Applicant: Oxford Technology Park

Proposal: Discharge of Conditions 10 (materials) and 11 (lighting plan) of
17/02233/F

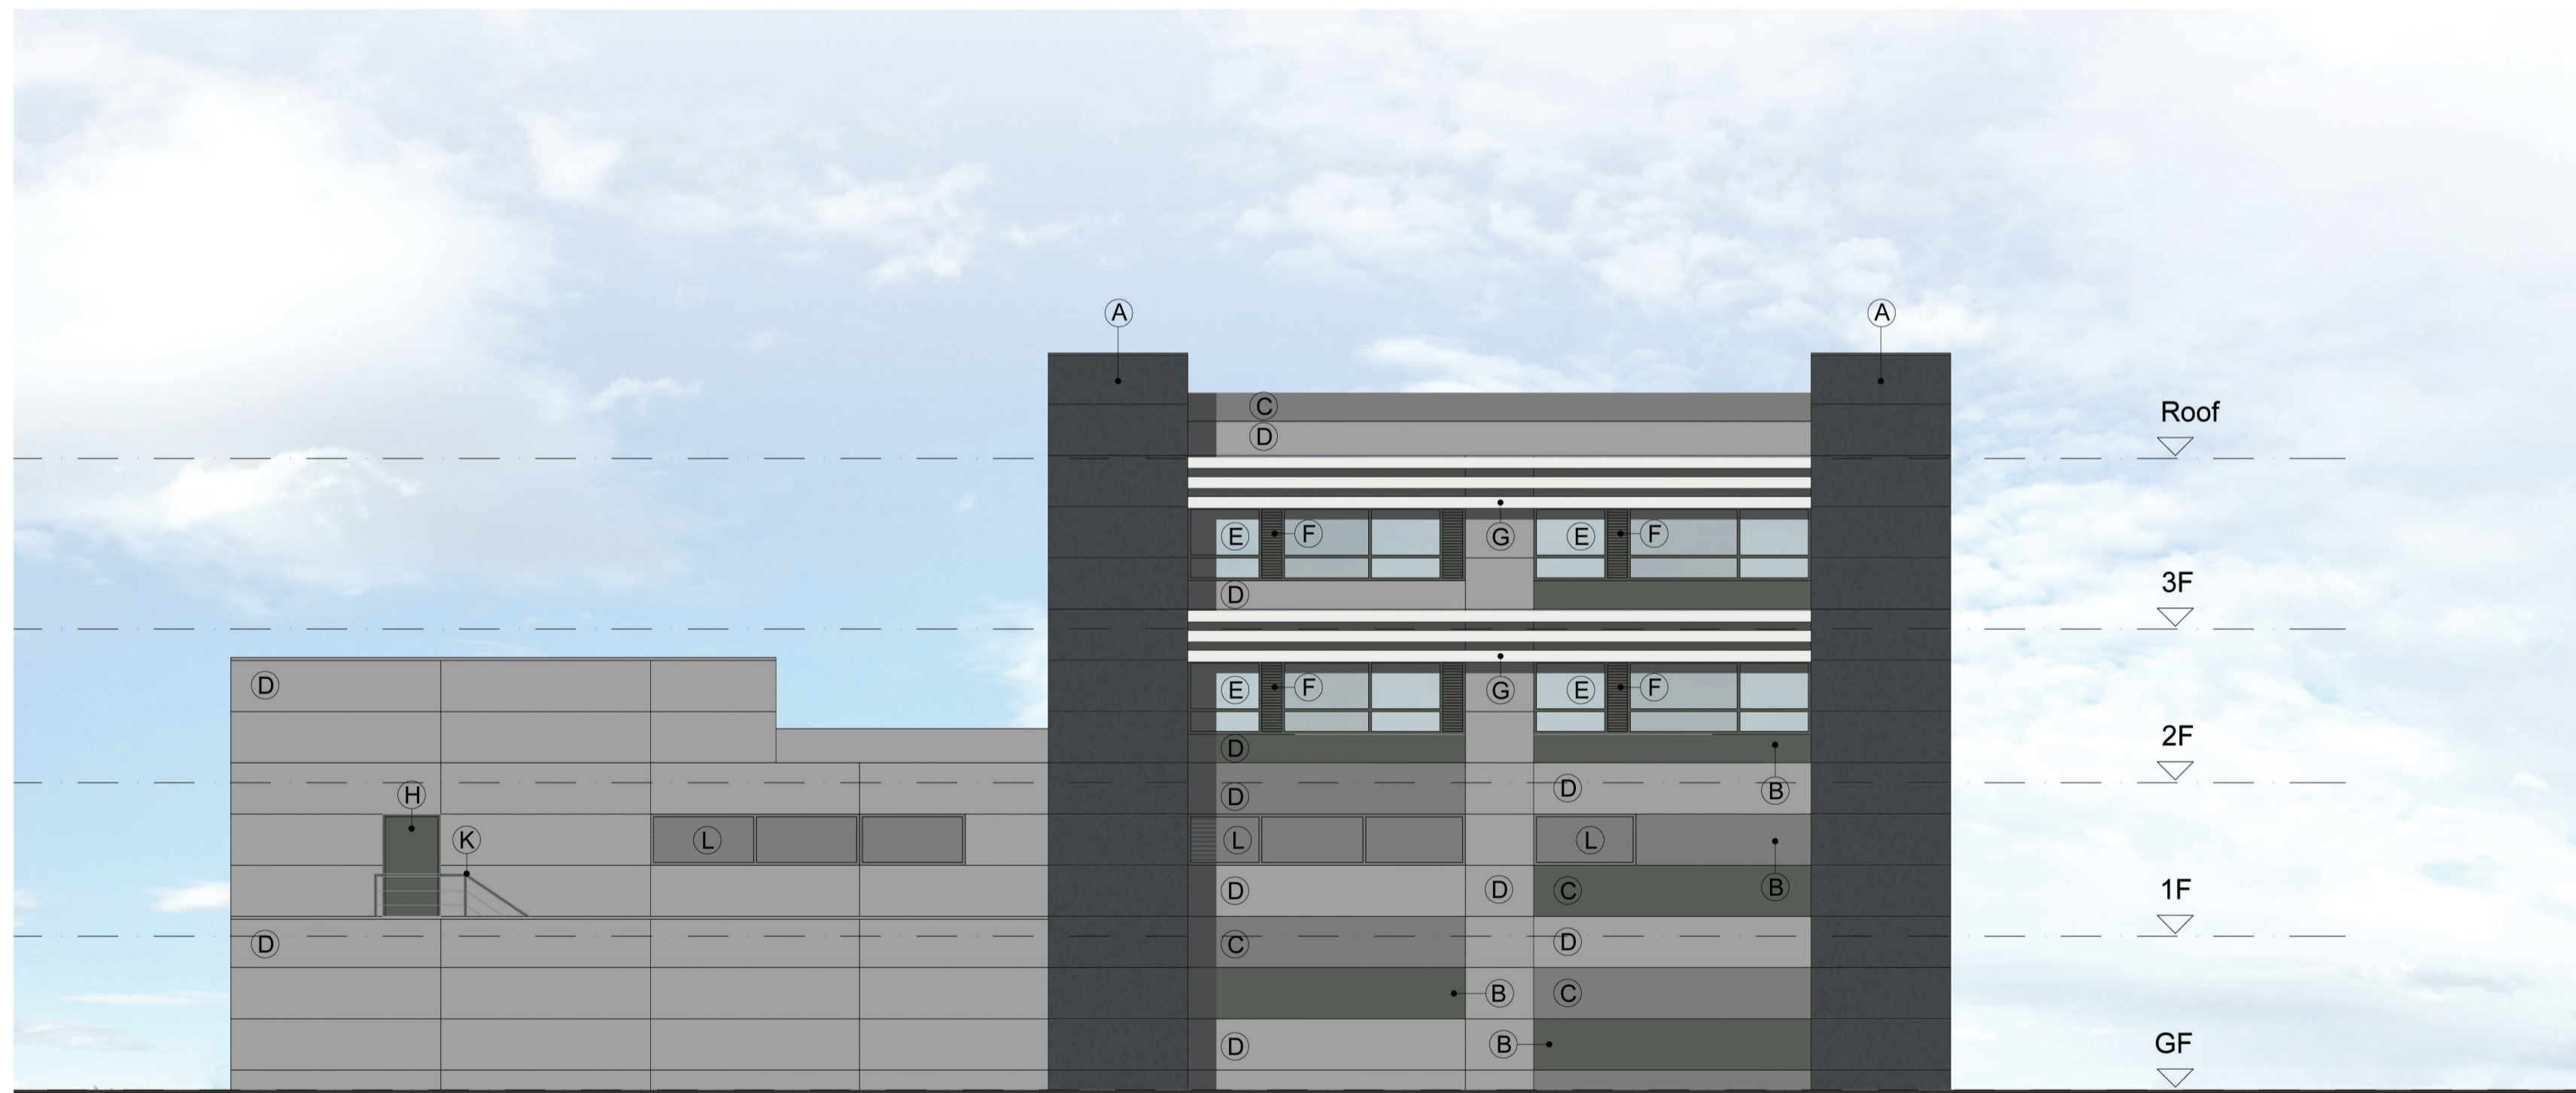
1.2. The samples submitted are considered acceptable, consistent with the details as on the approved drawings (but for the removal of the brise soleil, now subject to a variation of conditions application). The materials are appropriate for a modern building in this context. This condition can therefore be discharged.

Aluminium powder coated panels in colours RAL 7010, RAL 7037, RAL 9006
and equitone fibre cement facade panel in colour 'N251 Anthracite'
